WELWYN HATFIELD COUNCIL – DEVELOPMENT CONTROL
DELEGATED REPORT

APPLICATION No:	S6/2007/1107/FP
------------------------	------------------------

DESCRIPTION OF PROPOSAL:

The proposed development would be a single storey addition to the front elevation of the school. The proposal would measure a maximum 12.3m in width by 5.1m in depth with a gable sided roof with a ridge height of 5.0m.

Project NORTHAW CofE SCHOOL	
Client THE GOVERNORS	
Title PROPOSED PLANS	
Scale 1: 100 / 500	Drawn by ECW.
Date JULY '07	Drawing No. 02/16/02

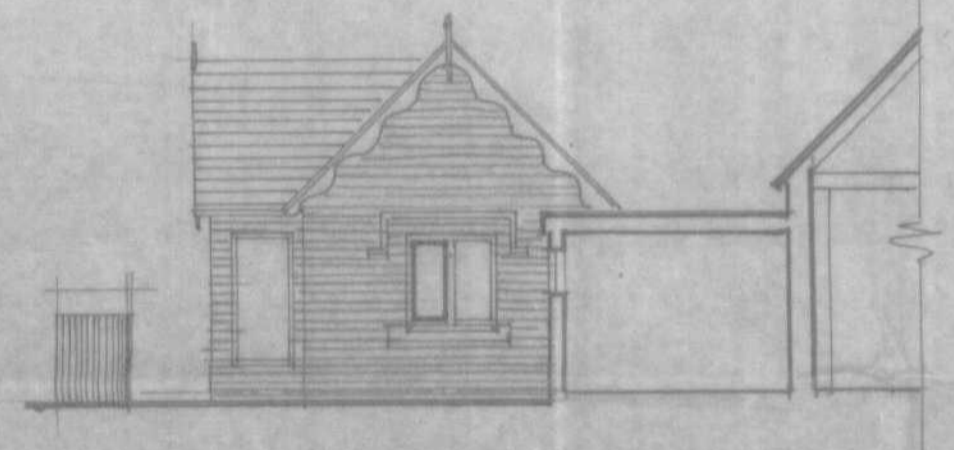
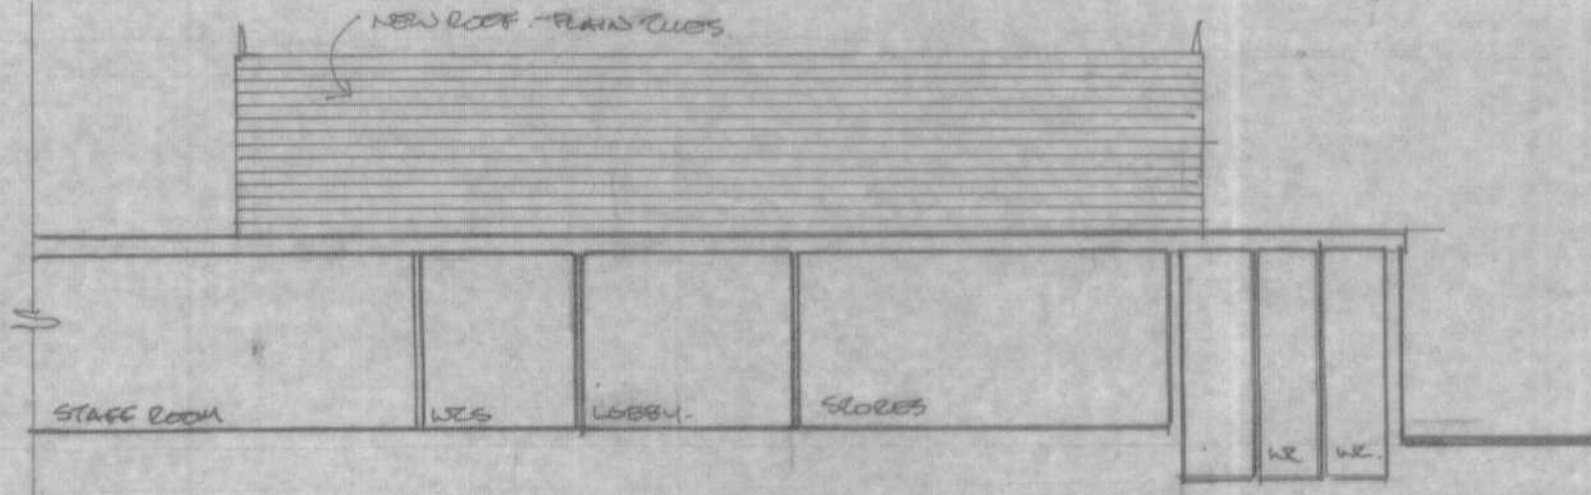
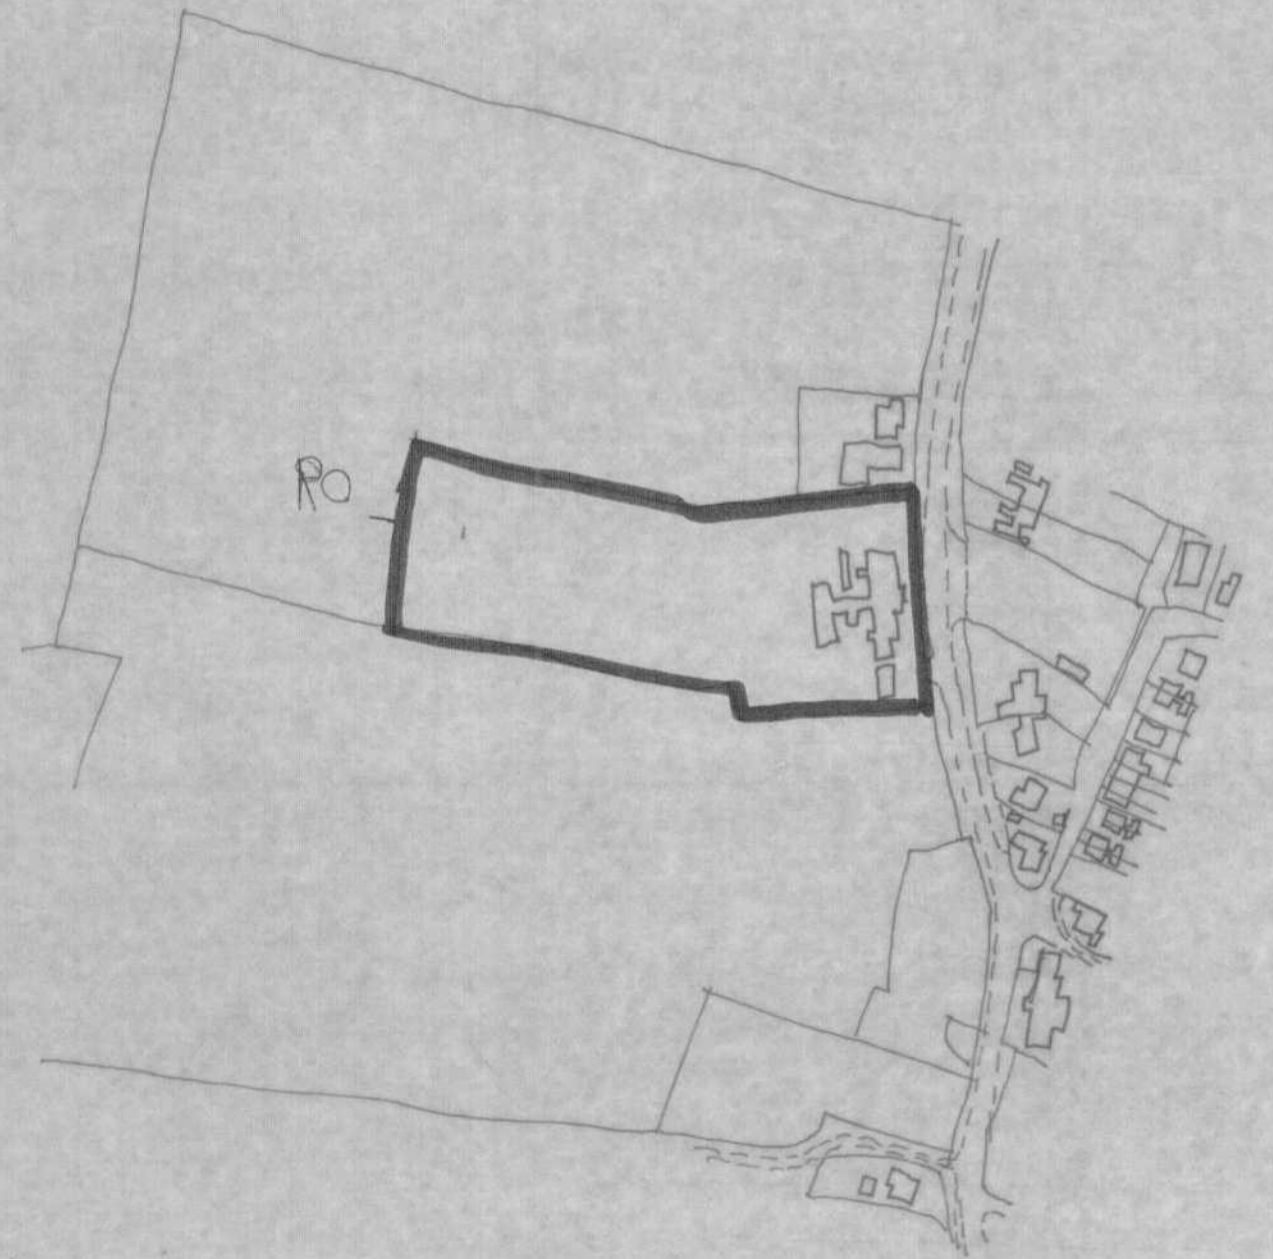
1. The proposed development has been designed to reflect the character of the original building. Although the proposal would have a design that would be in keeping with the original character of the school building, it would be sited very close to the front boundary adjacent to the public footpath (1.0m away). The proposal's close proximity to the footpath would make it appear particularly prominent within the street scene. The original school building and surrounding residential properties are set back from their front boundaries. Although the school has existing front extensions, they are single storey with a discrete flat roof design and maintain an acceptable distance from the front boundary. The proposed addition would appear overly dominant and incongruous within the street scene, this would be to the detriment of the character and appearance of the locality.

Both district and national policy does not have an allowance for significant and prominent extensions to school facilities within the Green Belt and development should not have an impact upon the openness of the Green Belt. The proposed development would be gable ended with a maximum height of 5m and would be sited forward of all of the existing built development on the site and within the surrounding street scene. The existing extensions to the school have mostly been sited and

designed to be set back from the front elevation of the main building and appear subordinate, which has prevented the existing buildings from appearing particularly prominent so they do not have an adverse impact upon the street scene. The proposed extension would appear particularly large and overly dominant. Due to the proposal's height, mass, bulk and siting, it would have an unacceptable impact upon the open character of the Metropolitan Green Belt. Furthermore, when considered with the existing development on the application site, the proposal would cumulatively have an excessive impact upon the openness of the Green Belt.

The proposed extension would form an overly prominent addition to the street scene and have an incongruous appearance. This would be to the detriment of visual amenities of the street scene and the character and appearance of the locality. The proposal is therefore contrary to Policies D1 and D2 of the Welwyn Hatfield District Plan 2005.

The proposed development would have an adverse impact upon the open character of the Metropolitan Green Belt, due to the bulk, siting and prominence of the proposed extension. The proposed development is therefore contrary to Policy RA1 of the Welwyn Hatfield District Plan 2005.
